**Response to action points  
arising from the Issue**

**Application by ESSO Petroleum  
Company Ltd for an Order Granting  
Development Consent for the  
Southampton to London Pipeline Project**

Application Reference EN070005

## A response to actions arising from the ISH on the draft DCO on 25 February 2020

Drawing title
**SITE SPECIFIC PLAN
 SOUTHWOOD COUNTRY PARK**

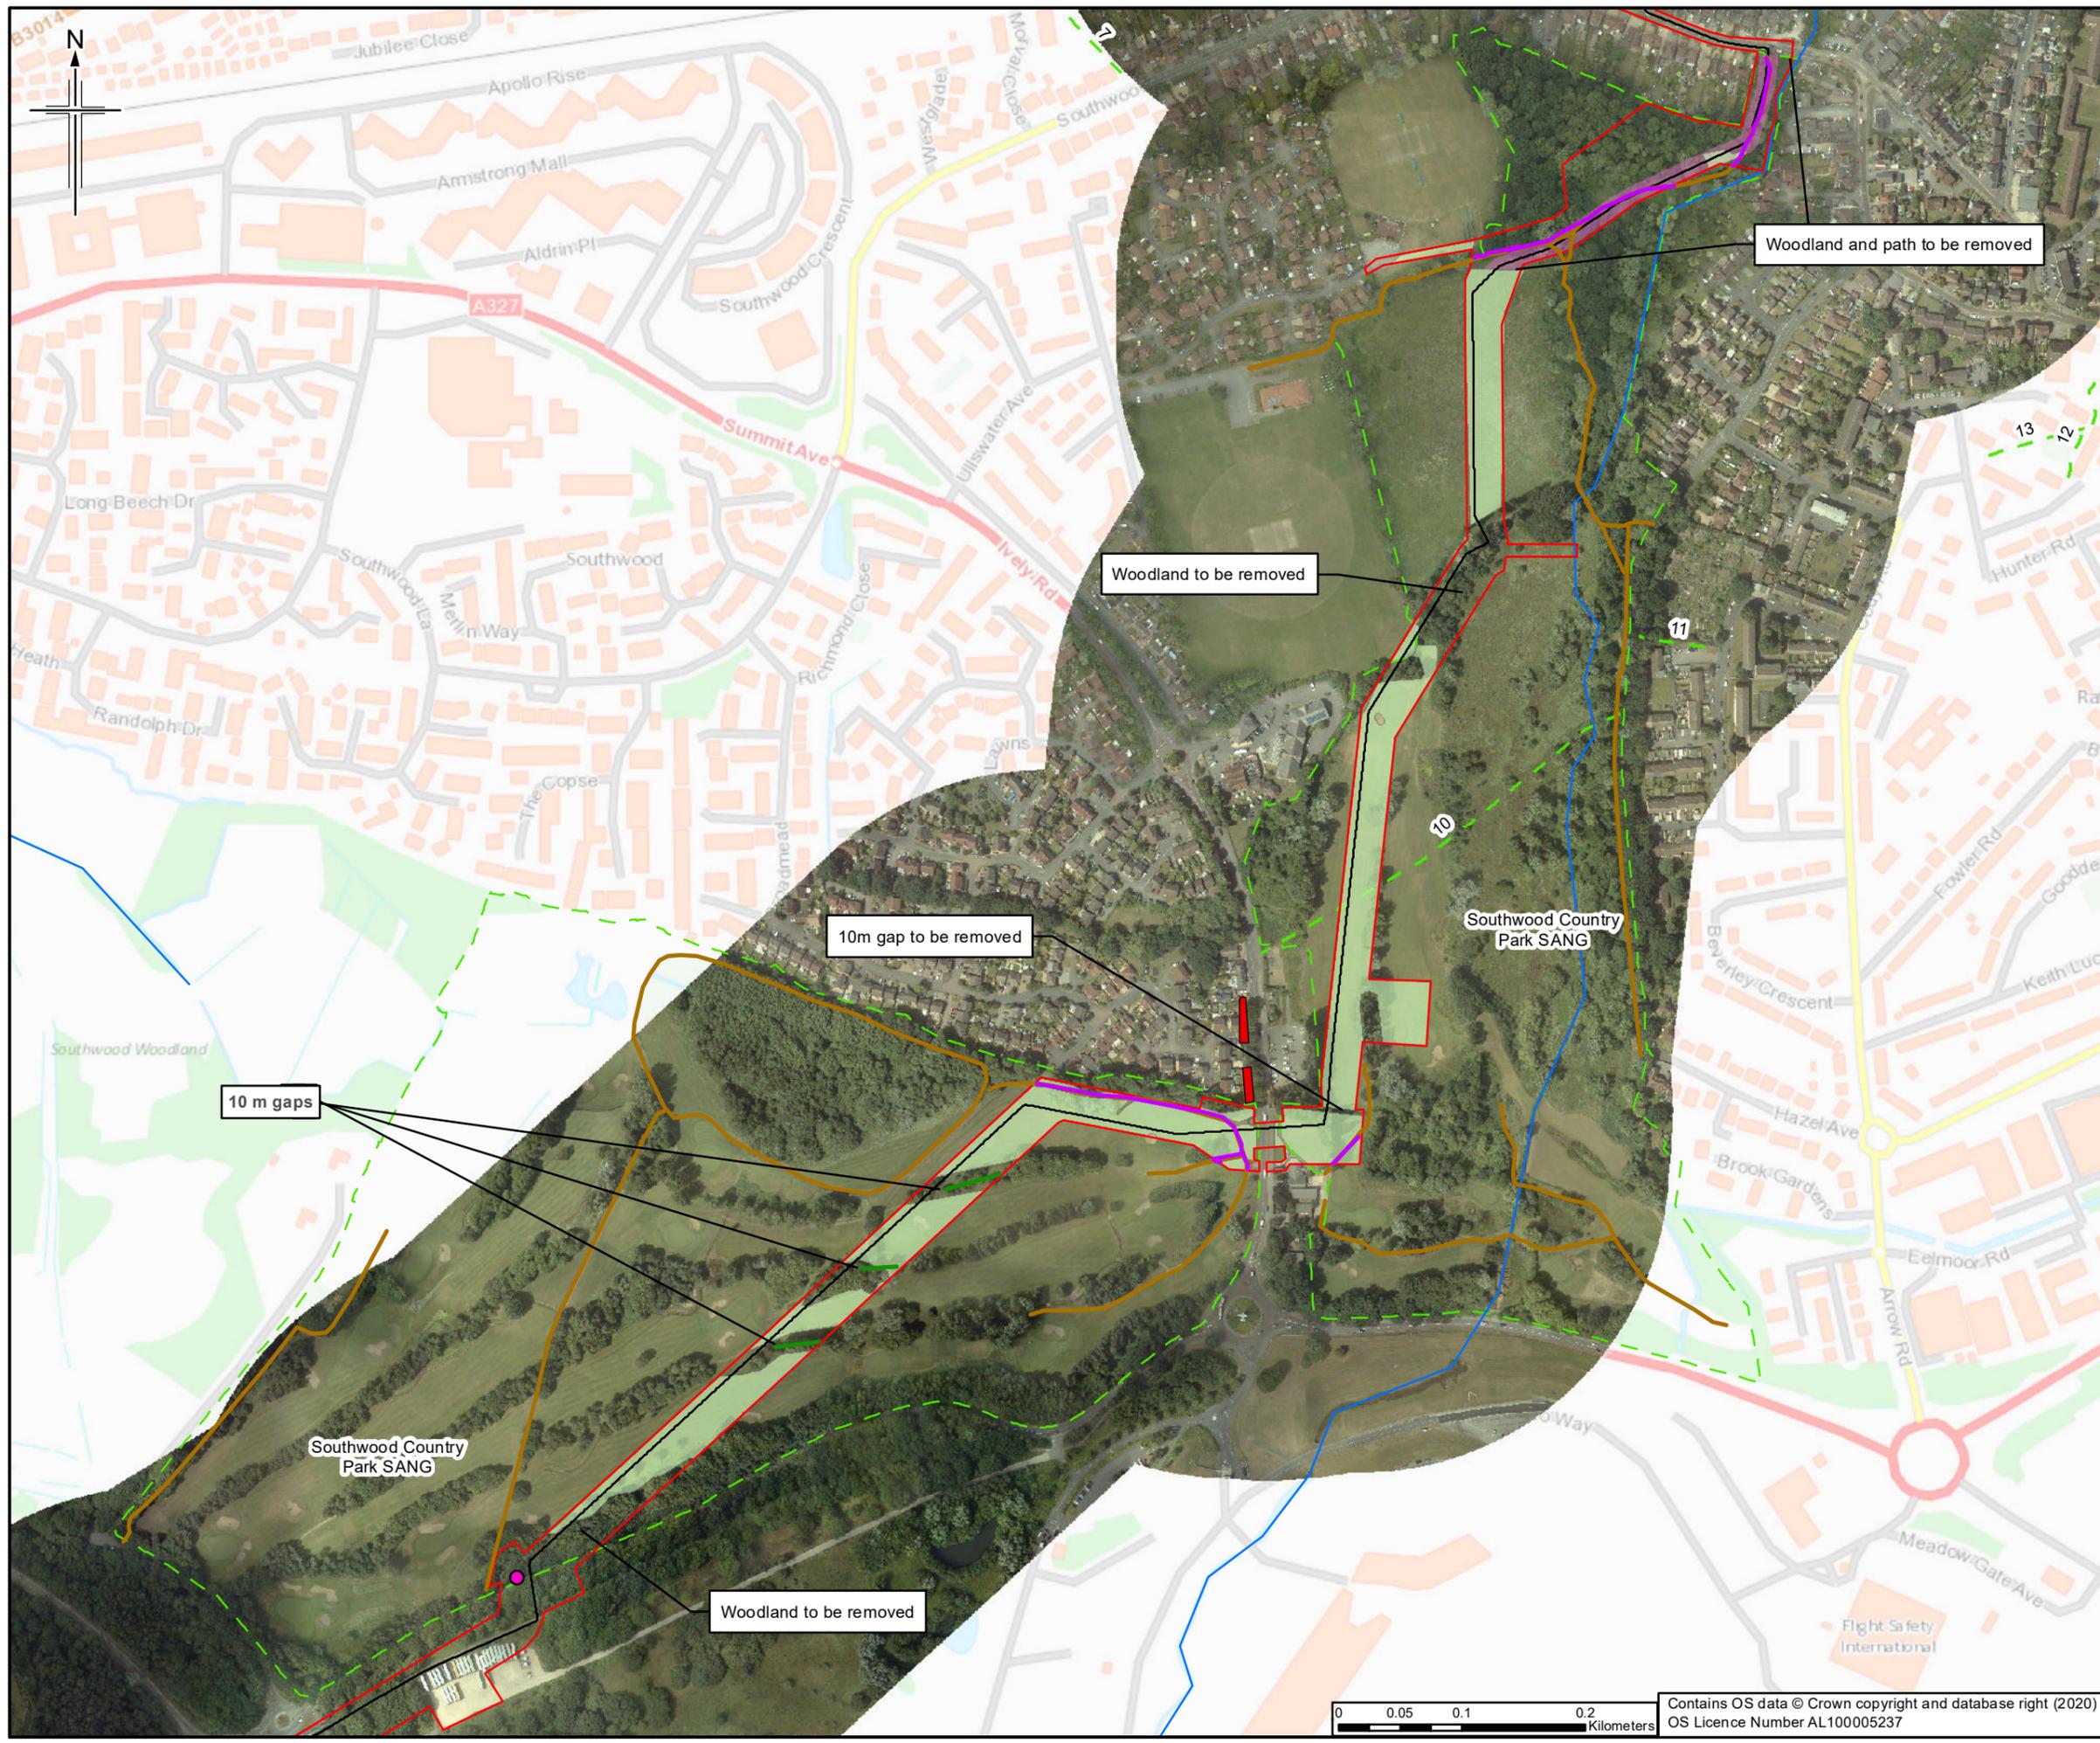
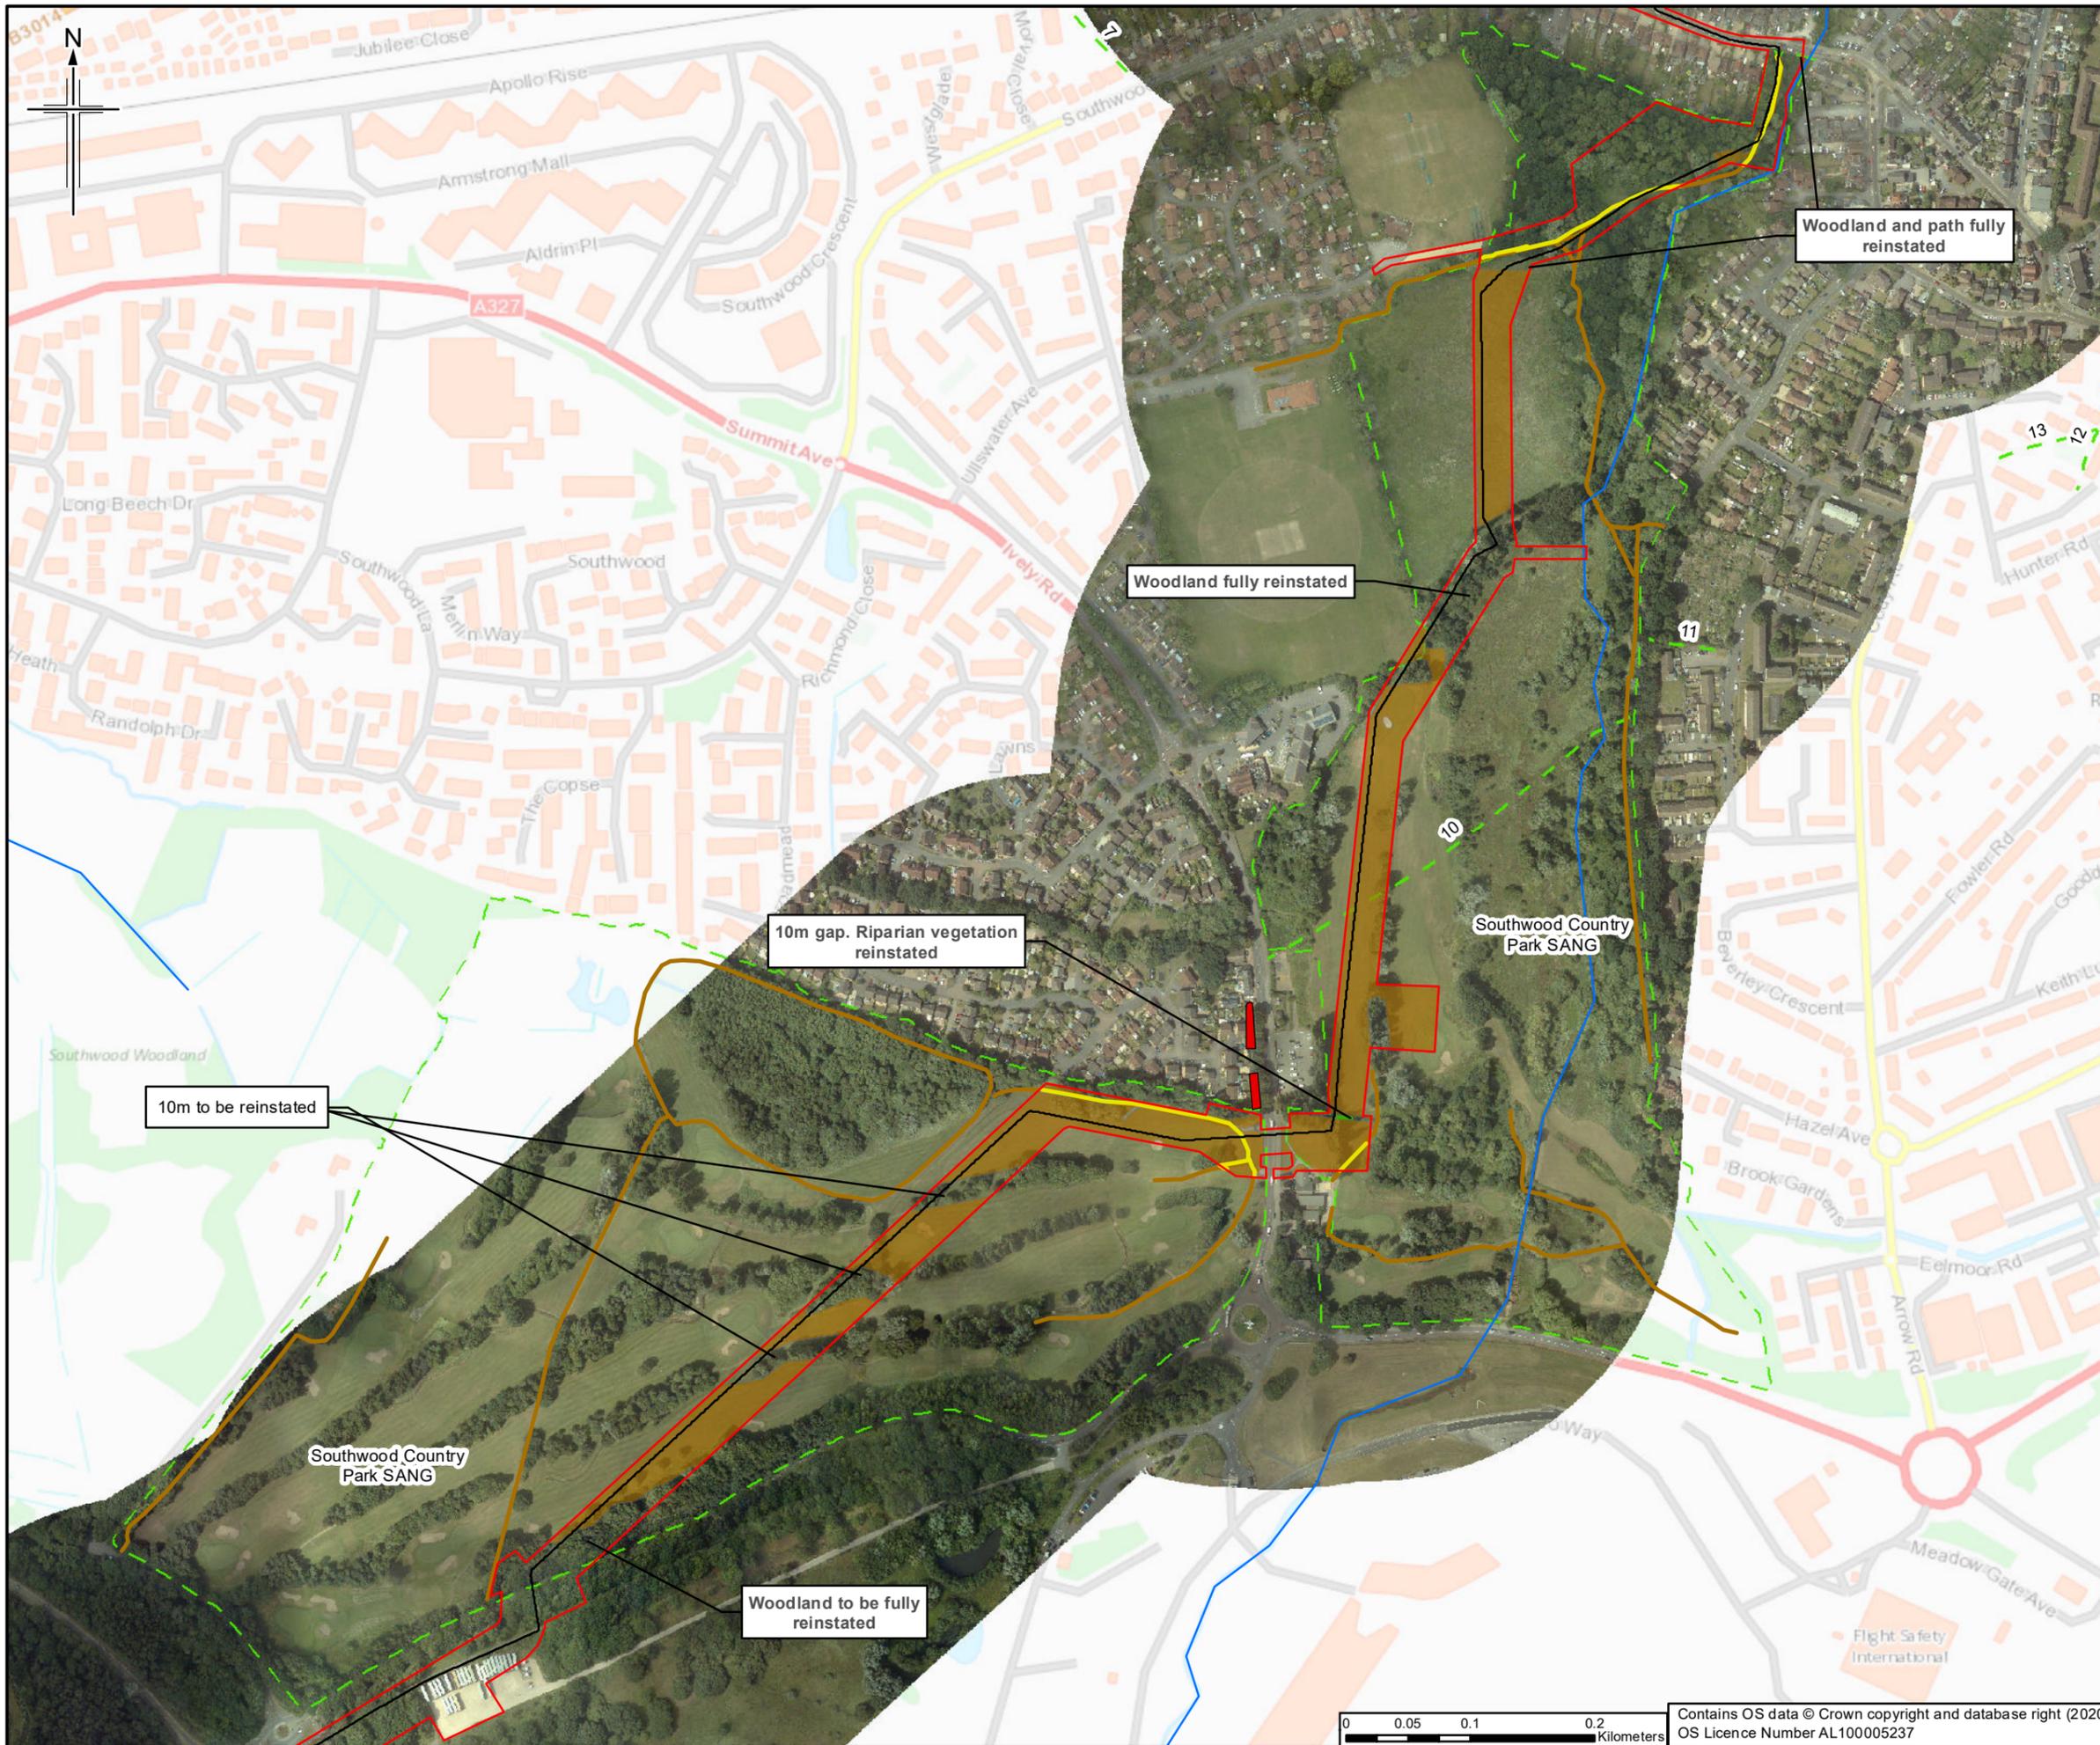
<p><b>Comment on the Site Specific Plan for QEP</b></p>	<p>exposed to burial. The alternative would be to “grade” the sides of the trench, avoiding root severance and allowing operators to feed the pipe beneath the roots but exposing a greater extent of roots both sides of the run, to the detriment of the tree. Naturally the extent of “grading” is determined by the depth of the trench.</p> <p>In summary, RBC cannot see how the development is achievable within the RPA of retained trees by trenching without seriously compromising the health of this important community woodland and the notable and veteran trees within it. Only trenchless insertion methods can achieve the Applicant’s objective without causing serious adverse environmental implications.</p> <p>Finally, the plan in the QEP Site Specific Plan needs to refer to RPAs from the BS, and not to the tree protection areas in the NJUG.</p>
